**Front Range-Midway Solar Project, LLC**

November 12, 2020

RE: Comment Response for Front Range-Midway Solar Project, LLC Amendment Application for Areas and Activities of State Interest ("1041"; AASI-20-002), Pre-Submittal #1

JOB NO.  
19-177  
SHEET  
4 OF 13

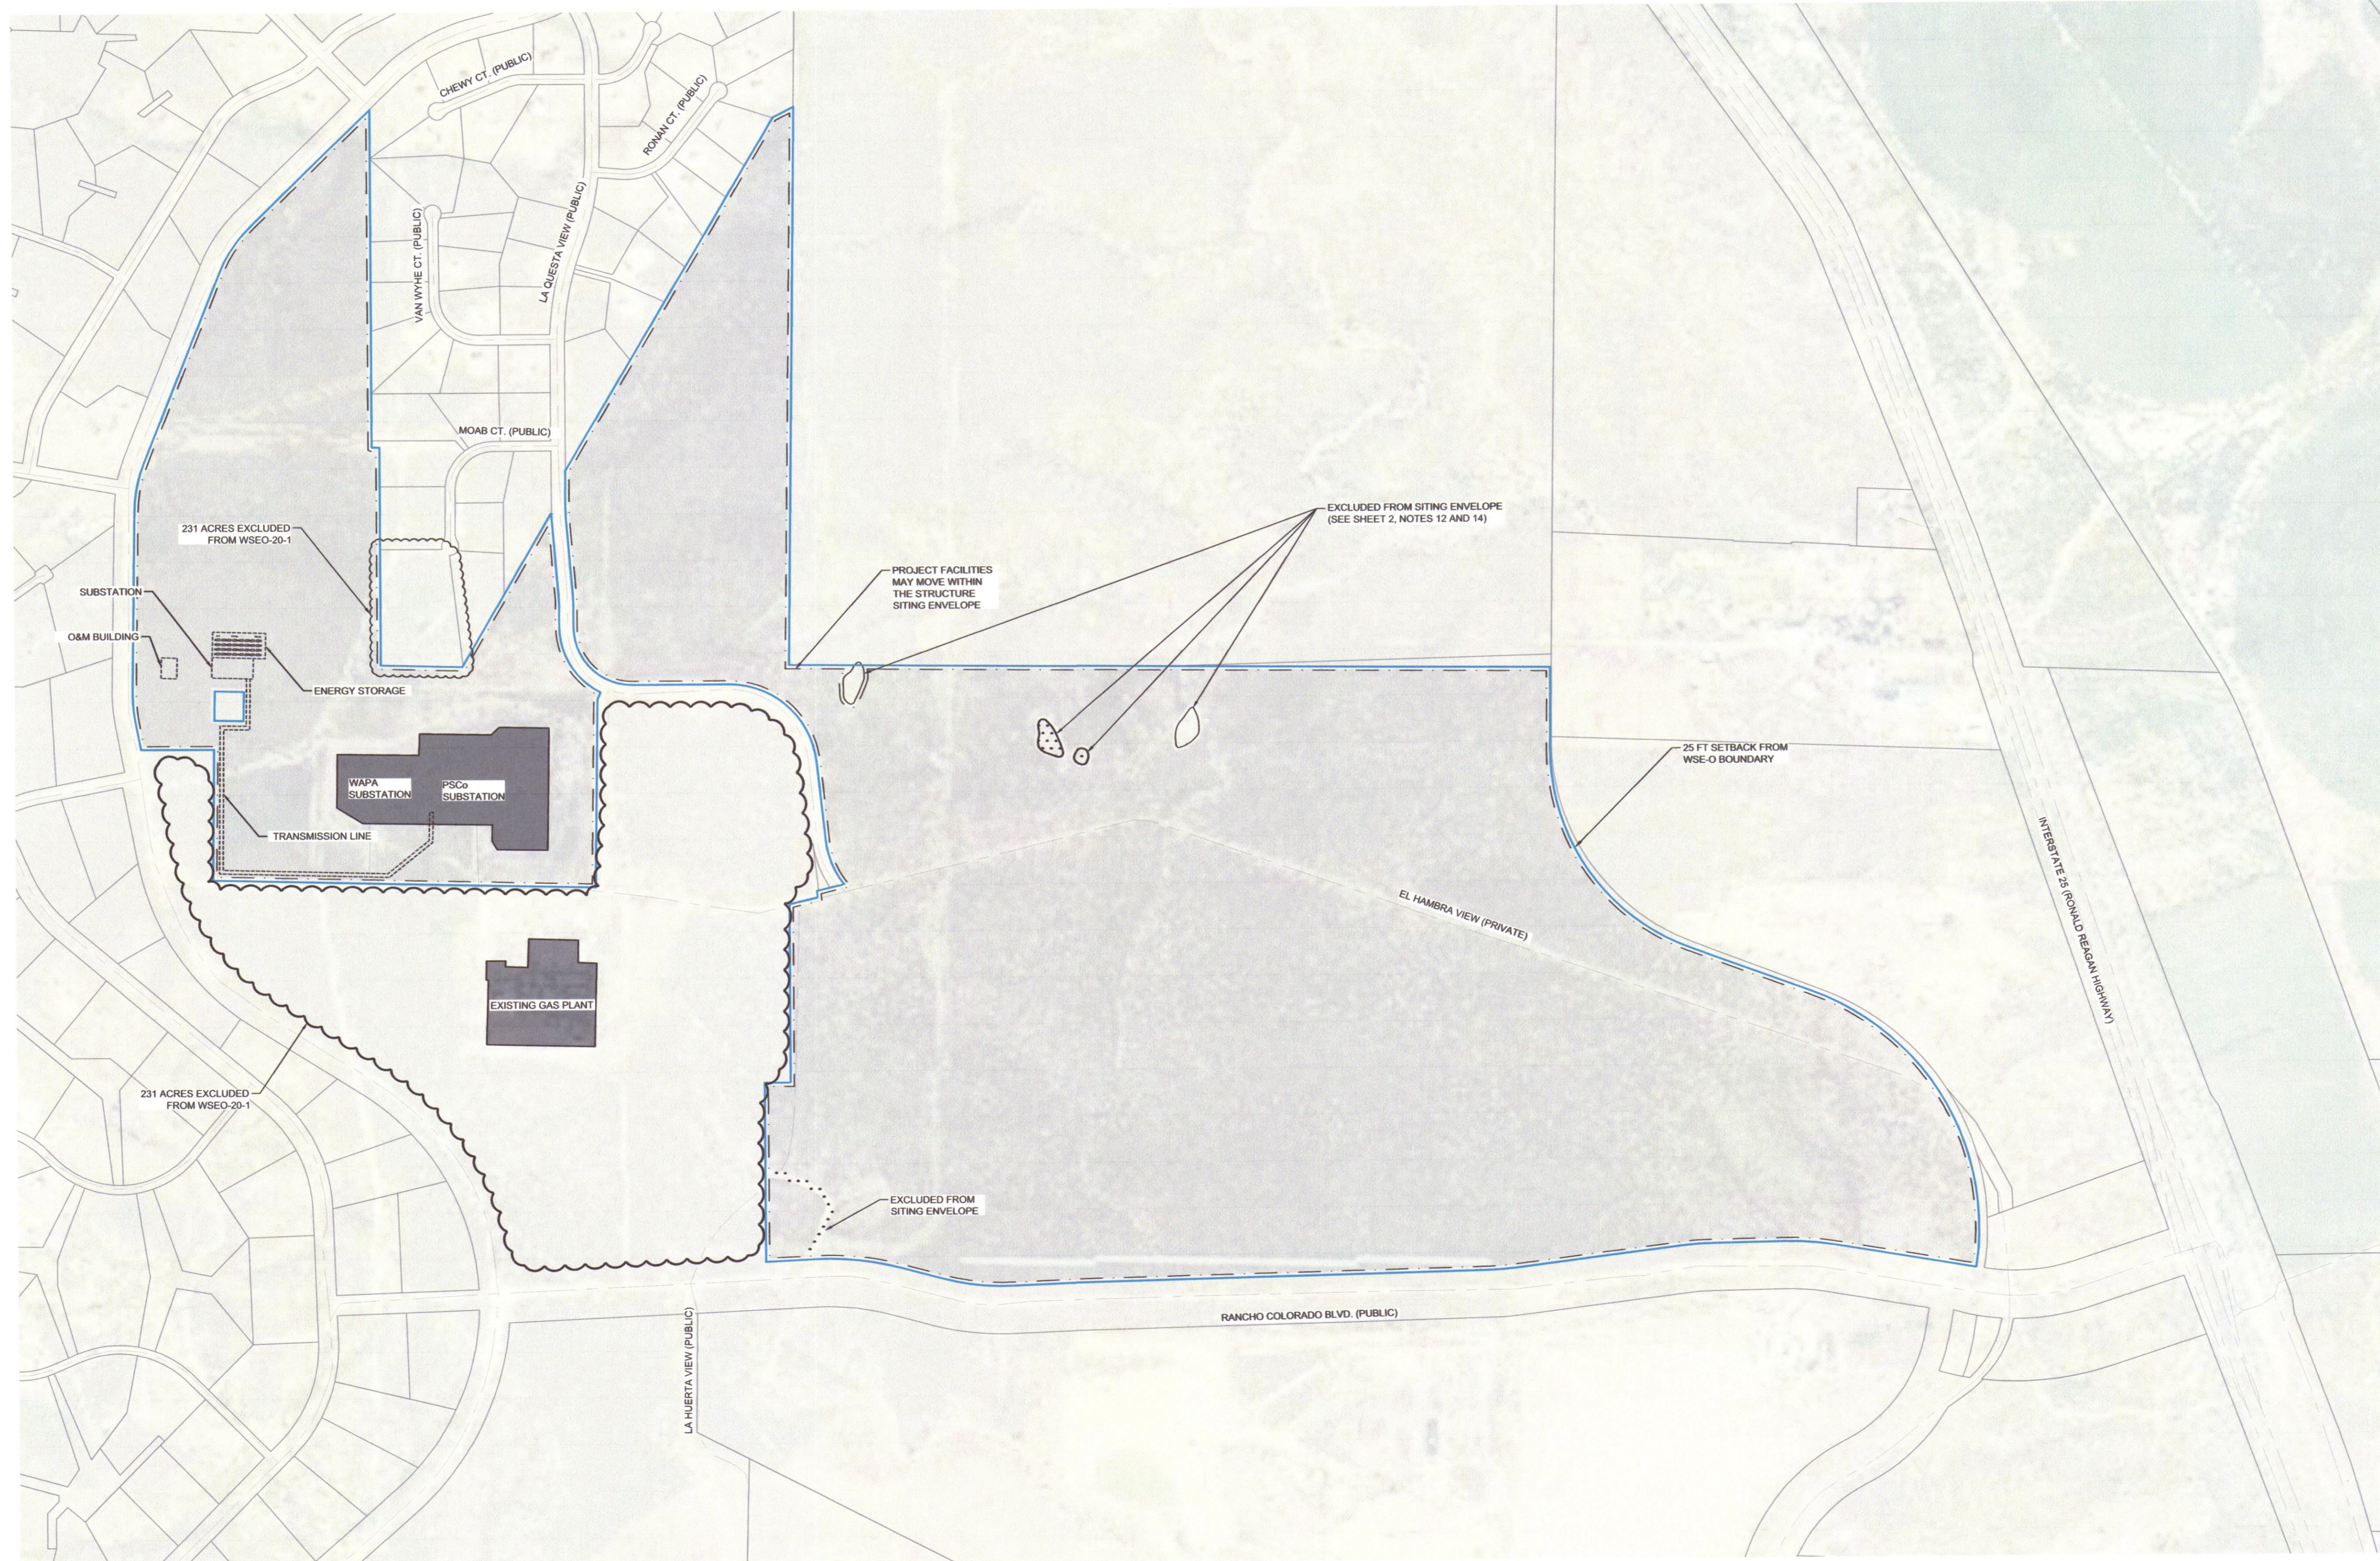
- a. Not Provided. The map does not provide the existing land uses or zoning in the area of the project. For instance, the Substations, landfills, and resident development sites should be labeled as an existing residence or substation Please revise.

**Response:** a) *The Application has been updated accordingly and identifies the land use, zoning, and adjacent lands in Attachment N El Paso County Zoning Map.* c) *The Application has been updated accordingly with discussion of the Master Plan and plans associated with the Master Plan.* d) *The Application has been updated accordingly and includes a discussion on the state energy policies and Pikes*

**WSE-O PLAN AMENDMENT (WSEO-20-1)**  
EL PASO COUNTY, COLORADO  
FRONT RANGE-MIDWAY SOLAR PROJECT  
SITE LAYOUT

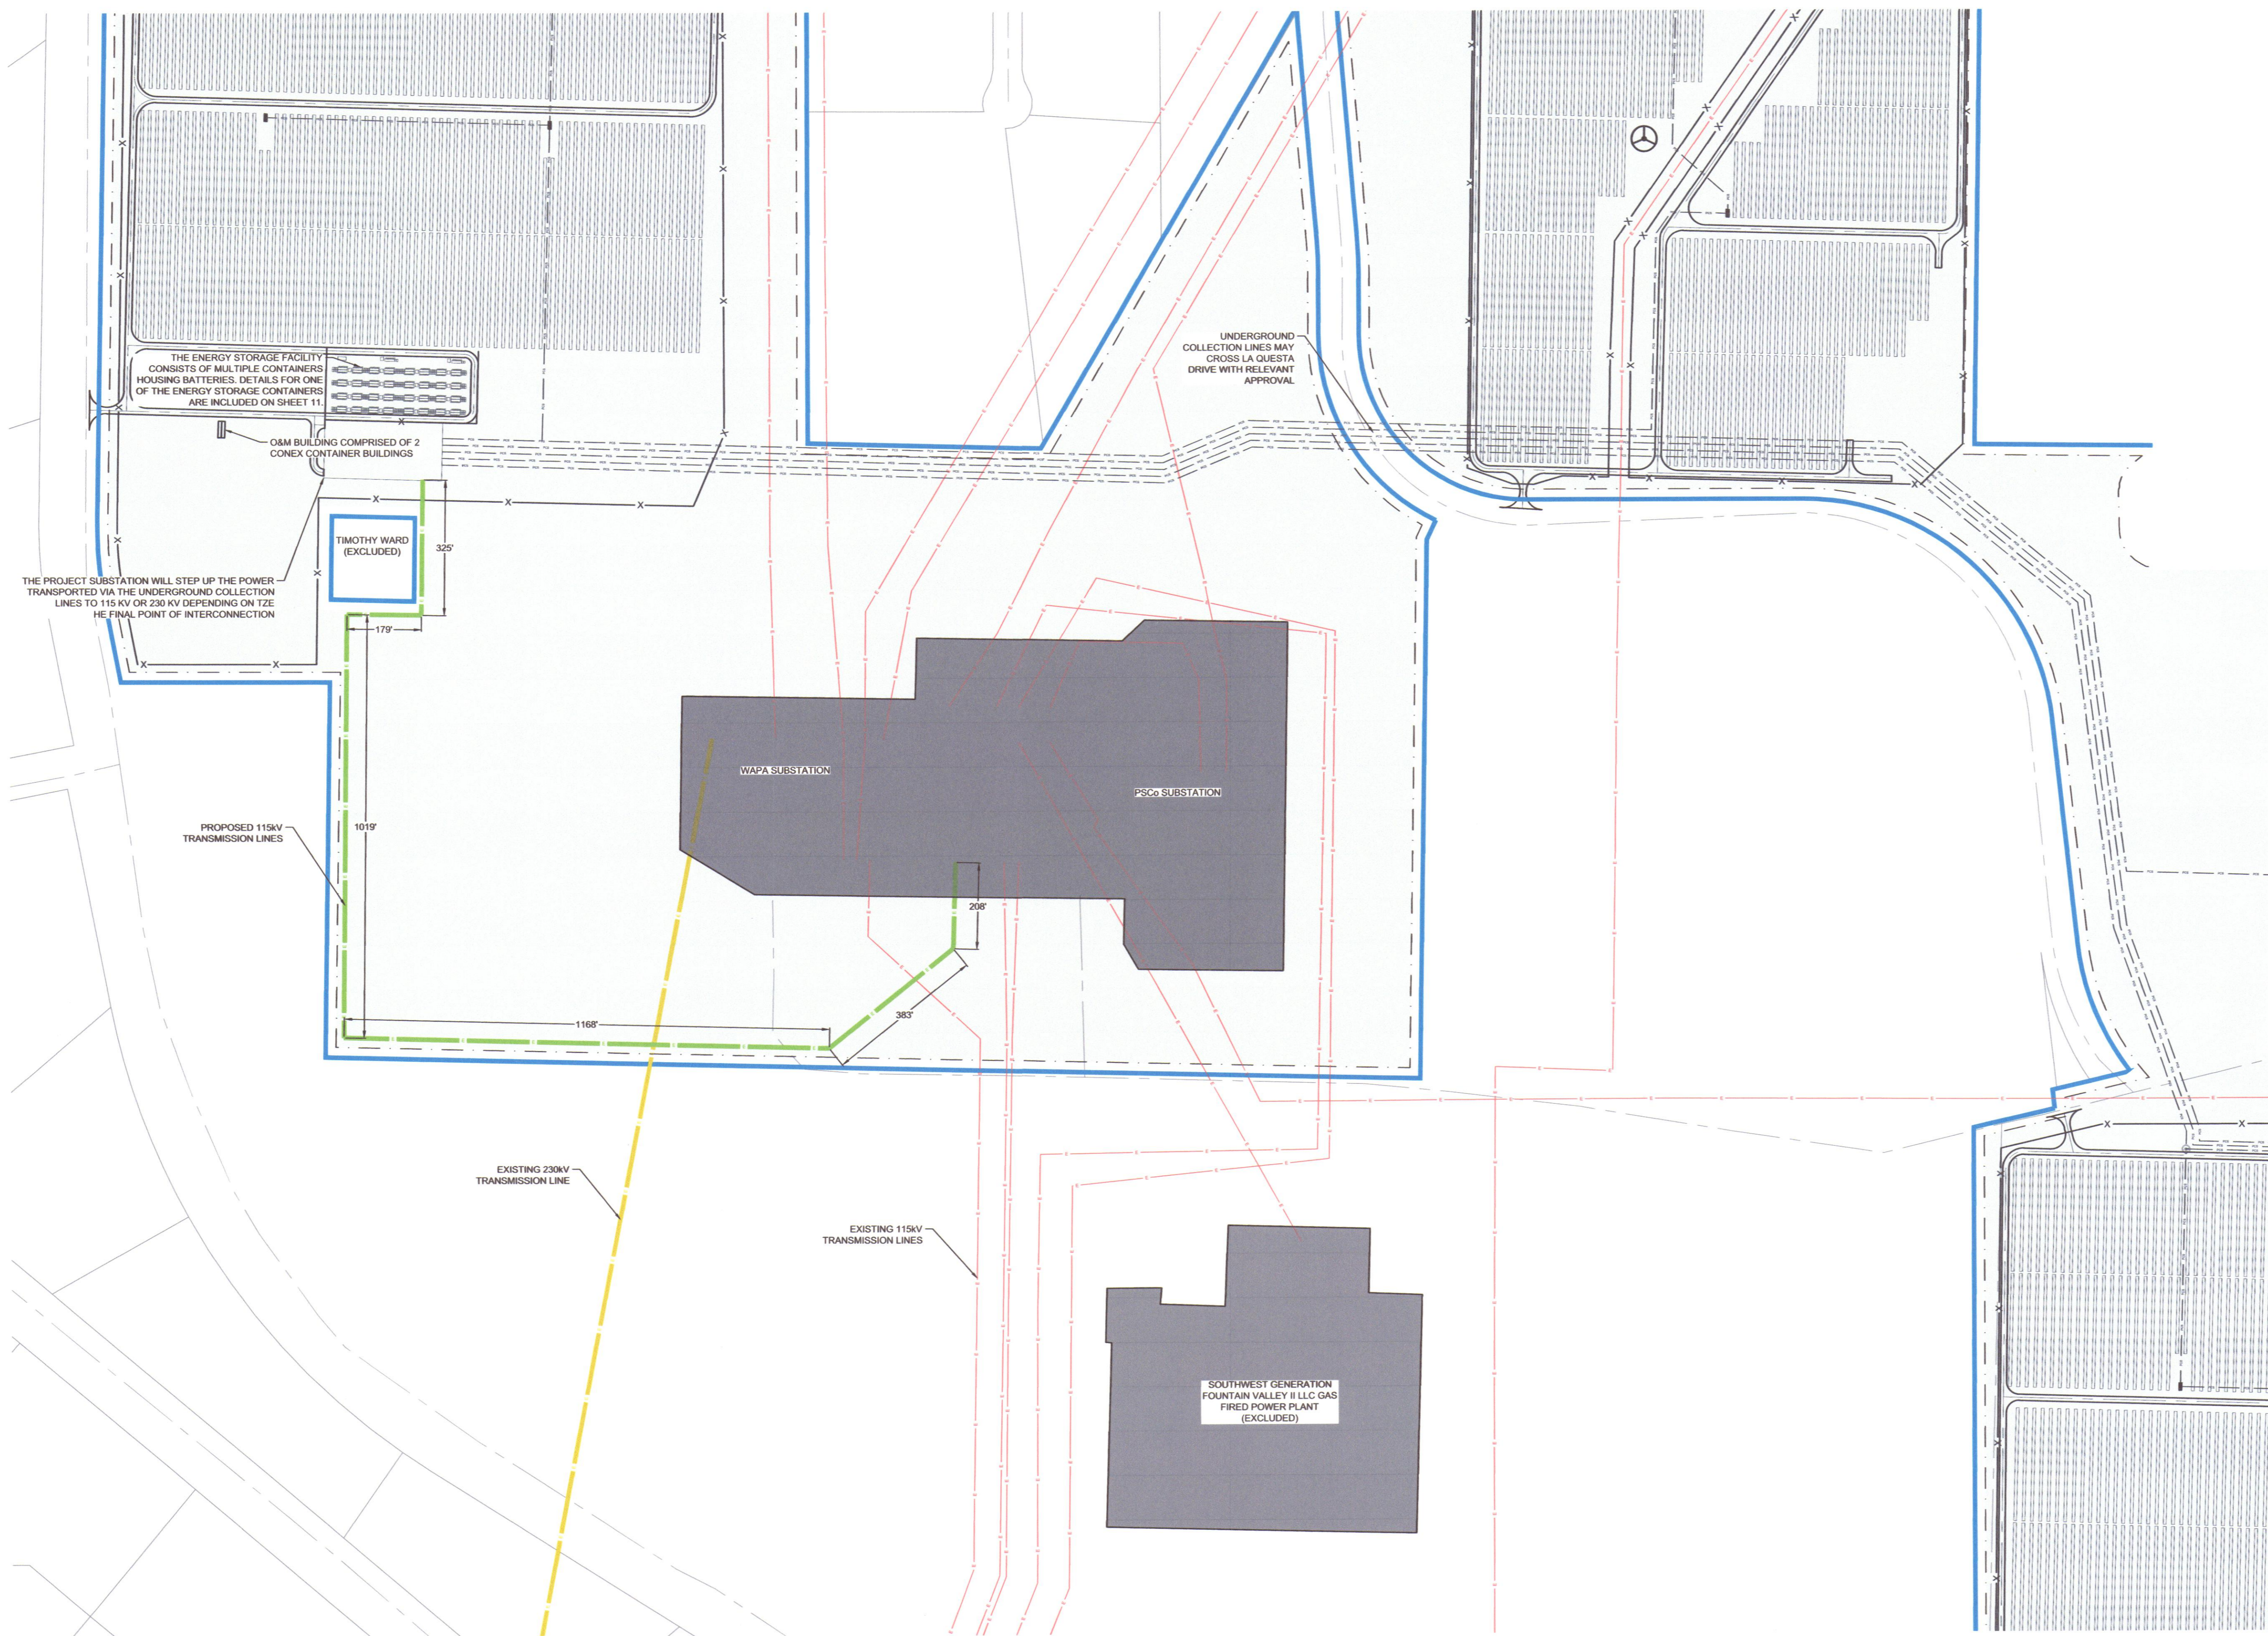
Two class III cultural sites (prehistoric) were identified within the project boundary area. [lithic reduction locale, surface assemblage is fragmented- moderate potential for buried cultural materials] The State Historic Preservation Officer (SHPO) and Midway Solar have agreed to preserve the sites by avoidance; however the area is shown to have solar arrays.

The sites (5EP7625 and 5EP7632) identified in the September 2016 final environmental assessment are located at the northern portion of the property east of La Questa as depicted above. A letter from the SHPO has been provided. If avoidance cannot be adhered to further excavation would be necessary, please provide further documentation. Please revise response accordingly. (Provide answer do not refer to old

**Response:** *The Application has been updated accordingly and includes information on the cultural resources that will be avoided.*
